**re: Response to City Comment
Proposed Development**
370 Athlone Avenue - Ottawa, Ontario

date: January 6, 2025

file: PG6996-MEMO.01

SOIL PROFILE AND TEST DATA SHEETS SYMBOLS AND TERMS

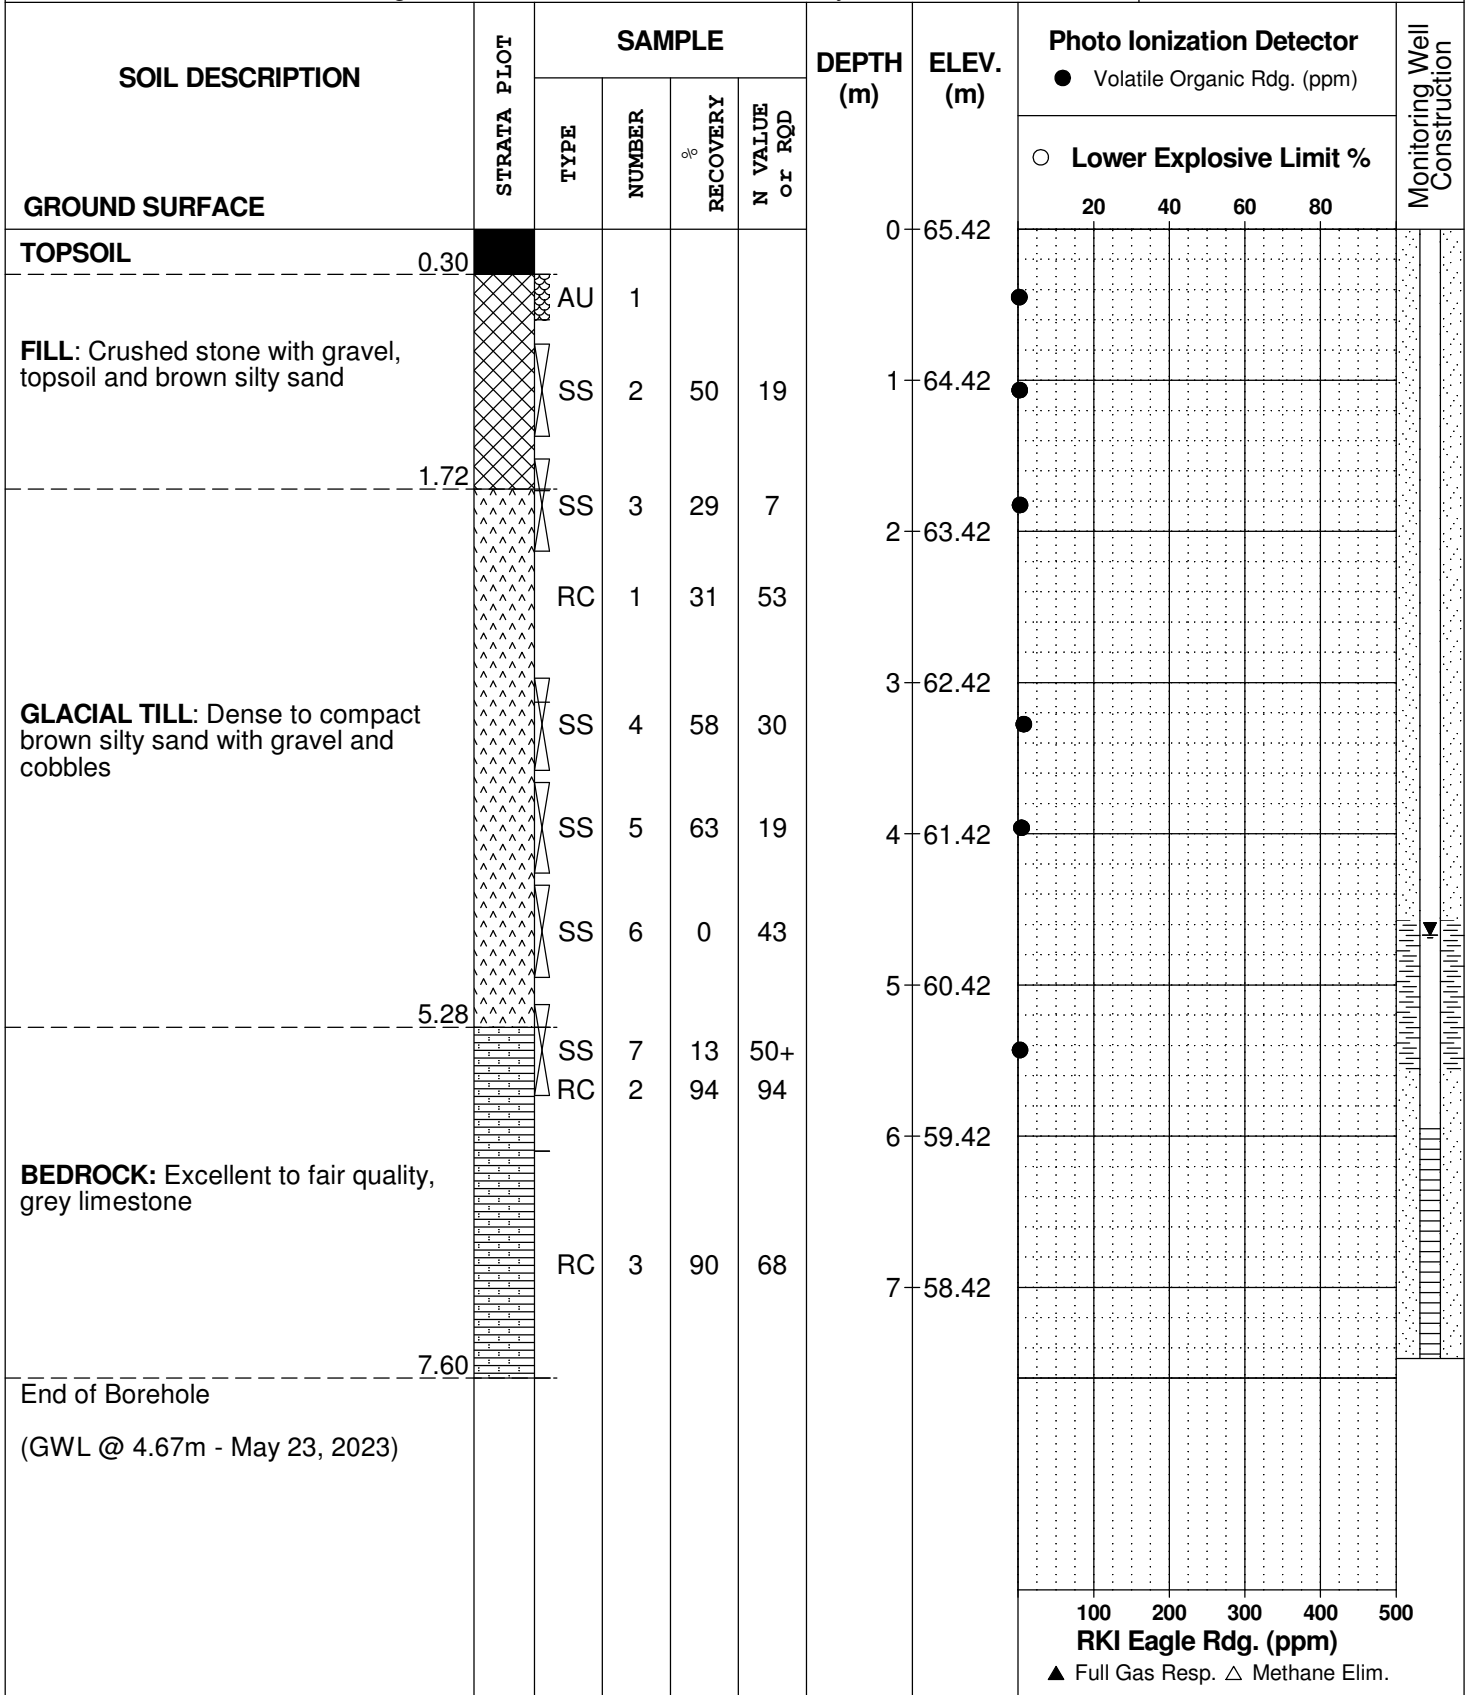
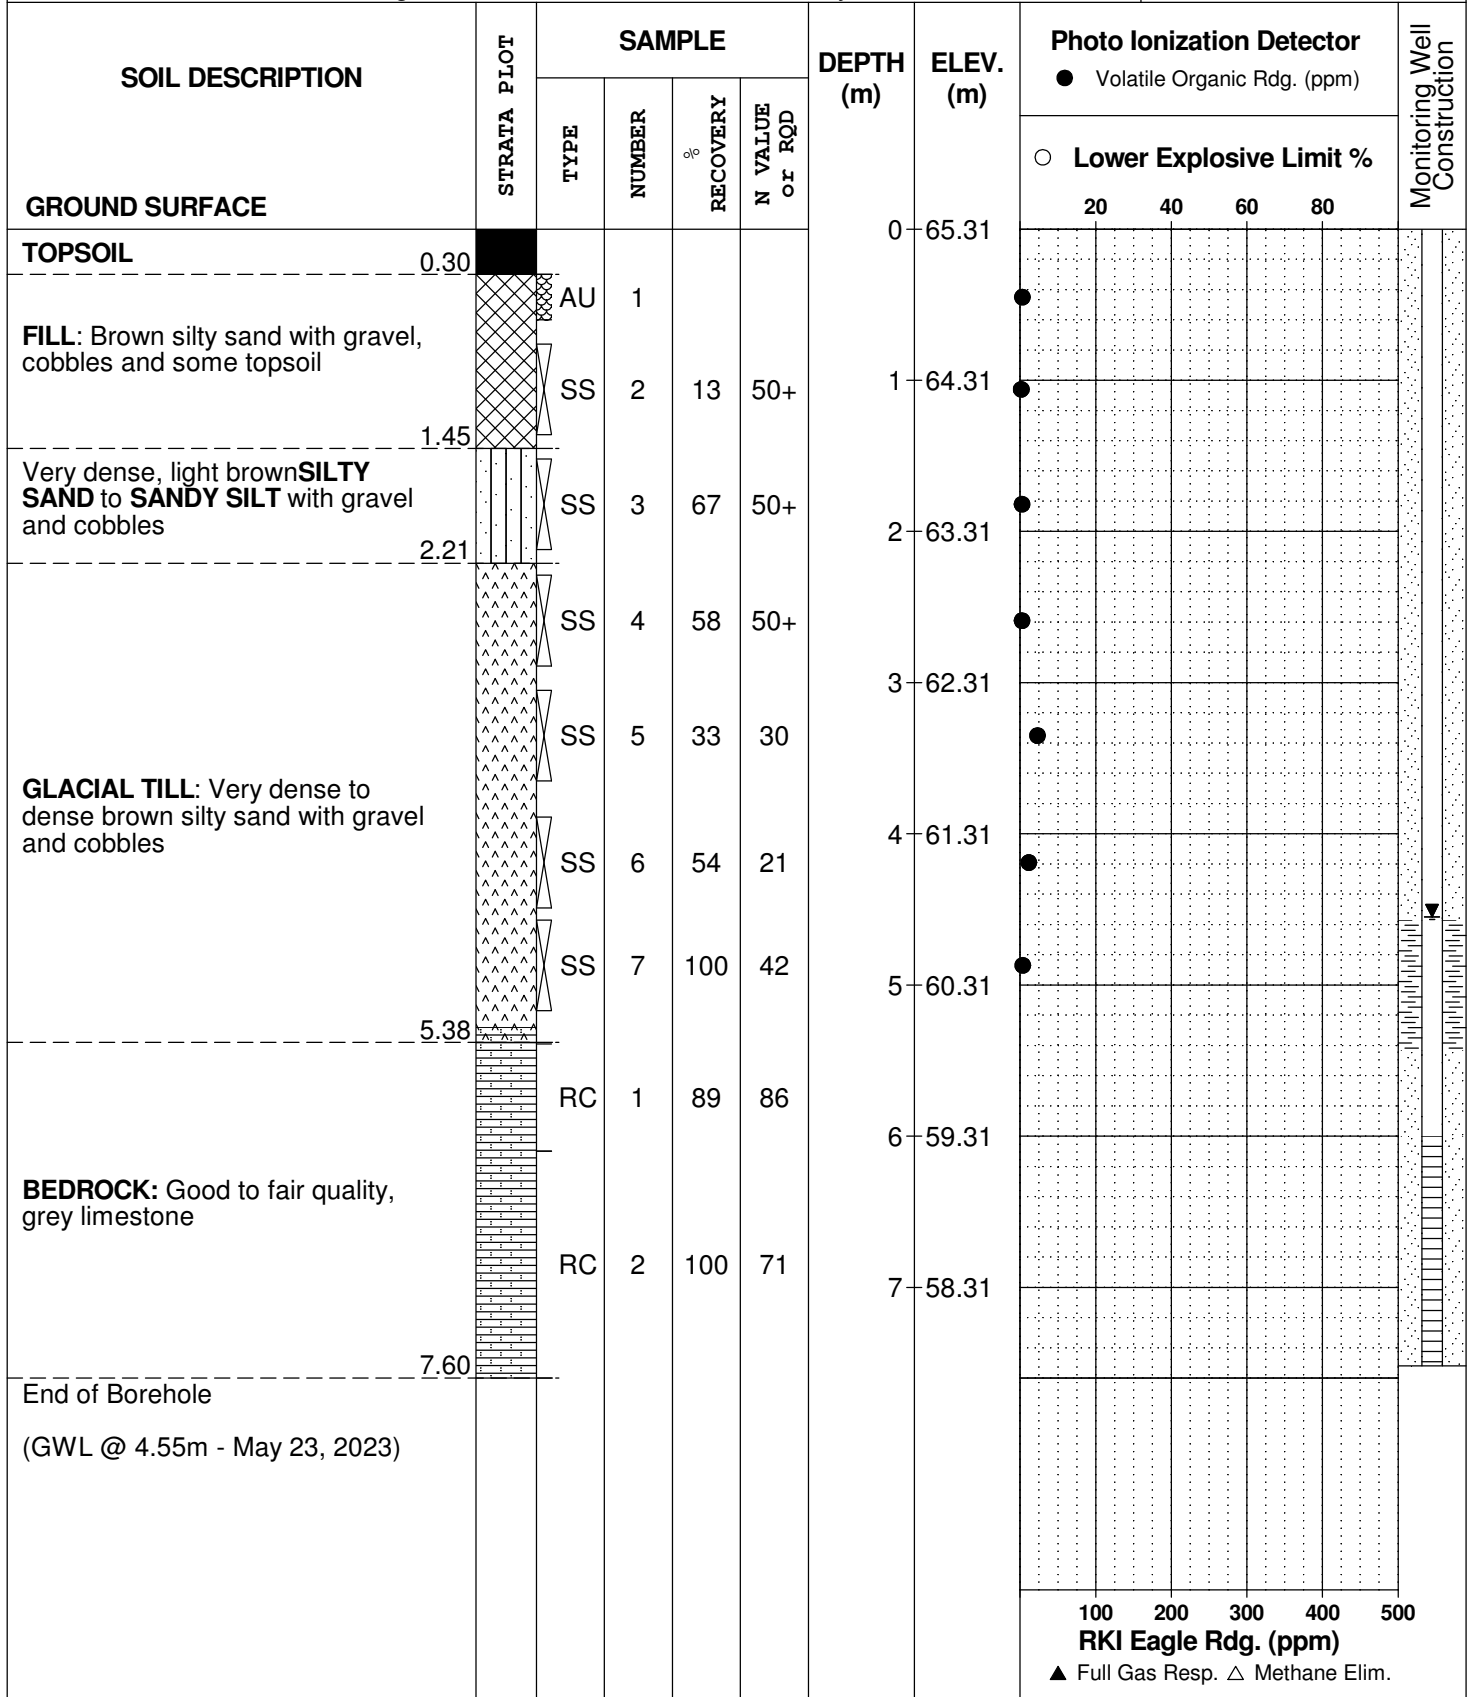
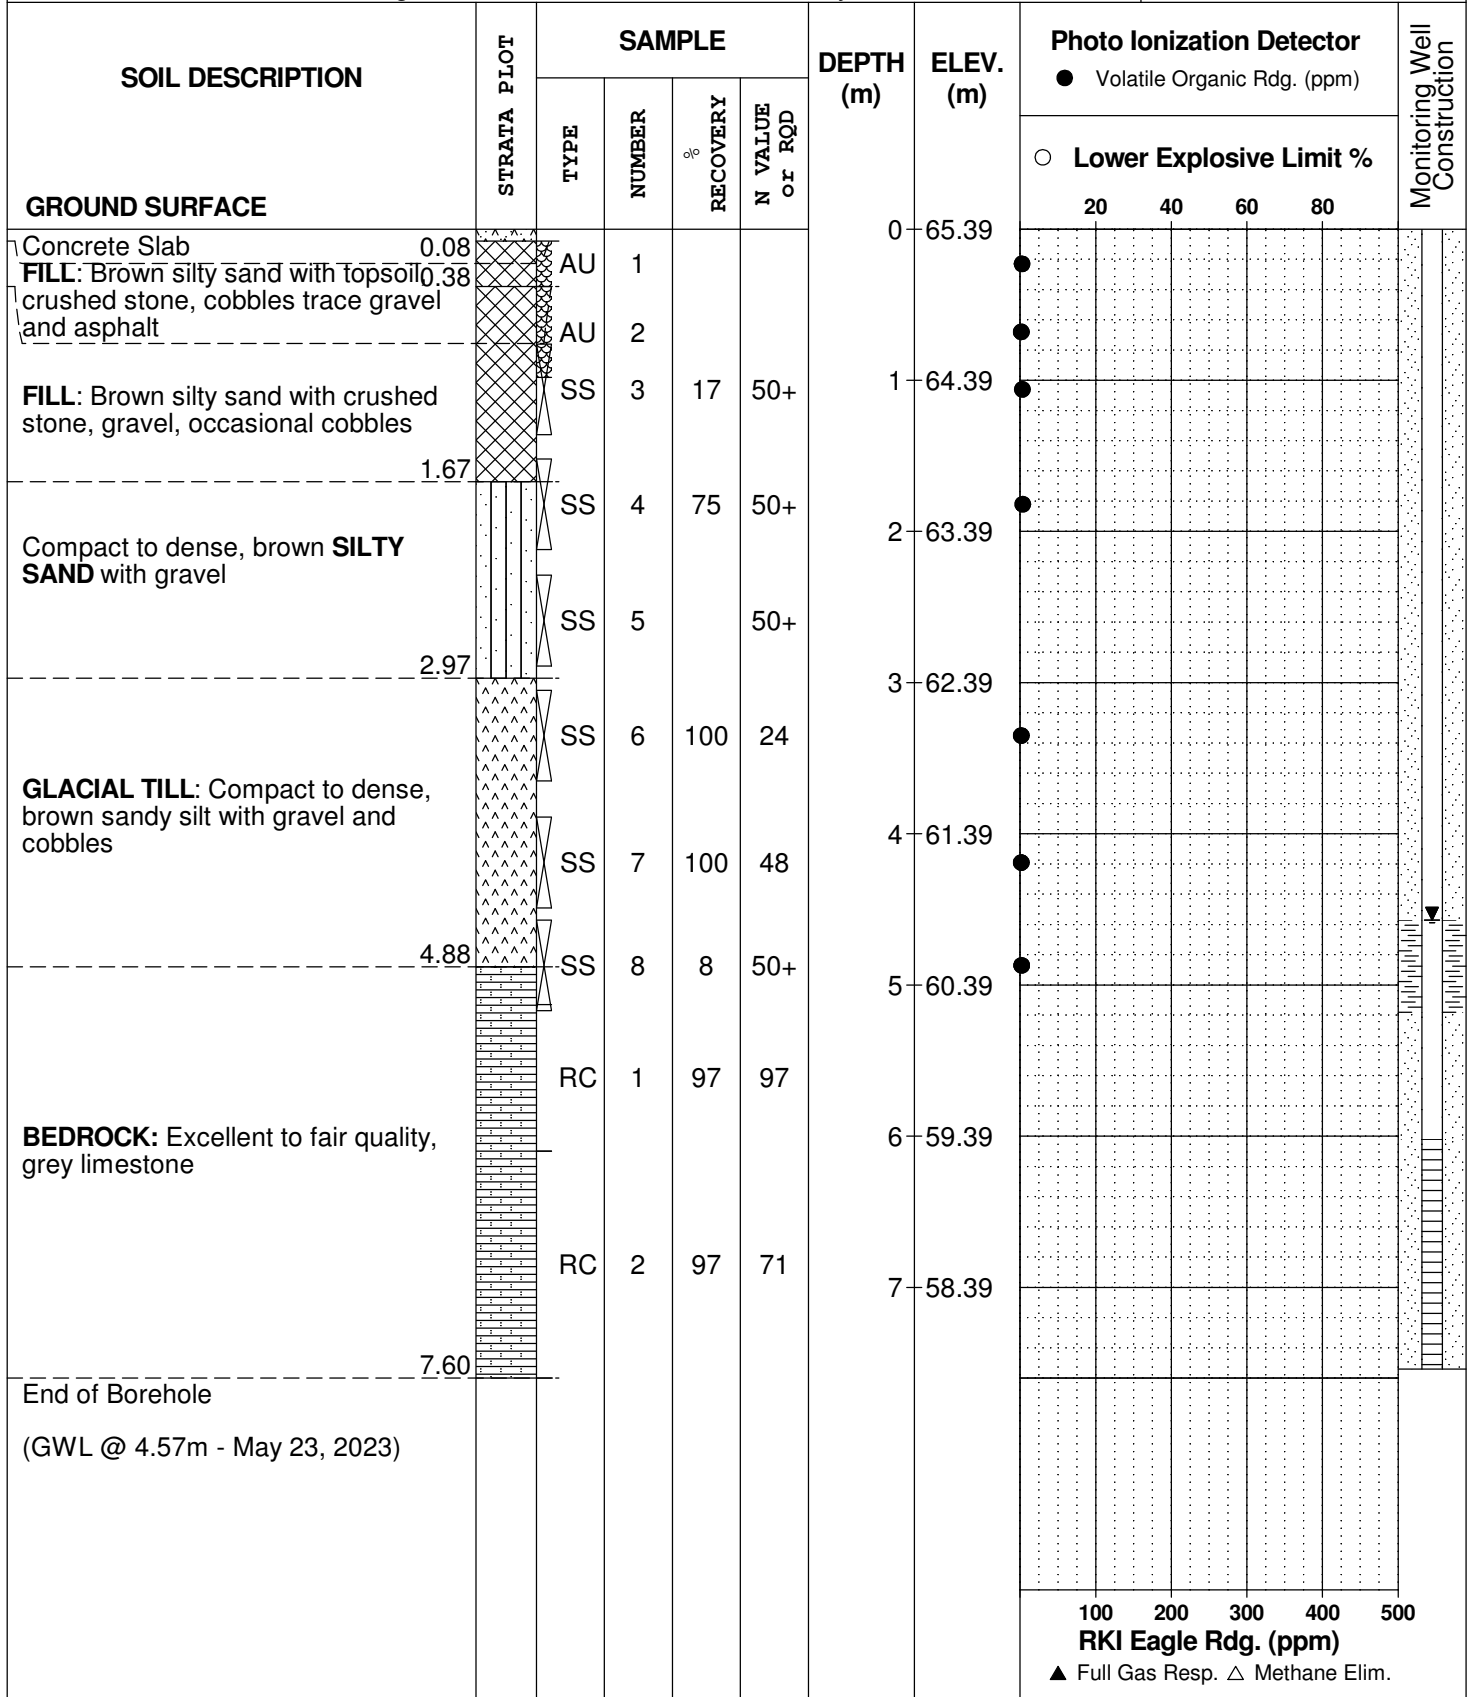
Comment 11: *Please revise one of the above referenced reports to ensure consistency. The Geotechnical Investigation and Phase II - ESA reference the same borehole data, findings summarized in each report shall be consistent in consideration of the identified soil contamination.*

Response: The original Geotechnical Investigation Report for this site referenced fill depths of 1.5 to 1.7 m below the existing ground surface, while the Phase II – Environmental Site Assessment (ESA) referenced fill depths of 1.45 to 1.76 m.

The updated Geotechnical Investigation Report, referenced above, now references fill depths of 1.45 to 1.76 m, which matches the Phase II – ESA.
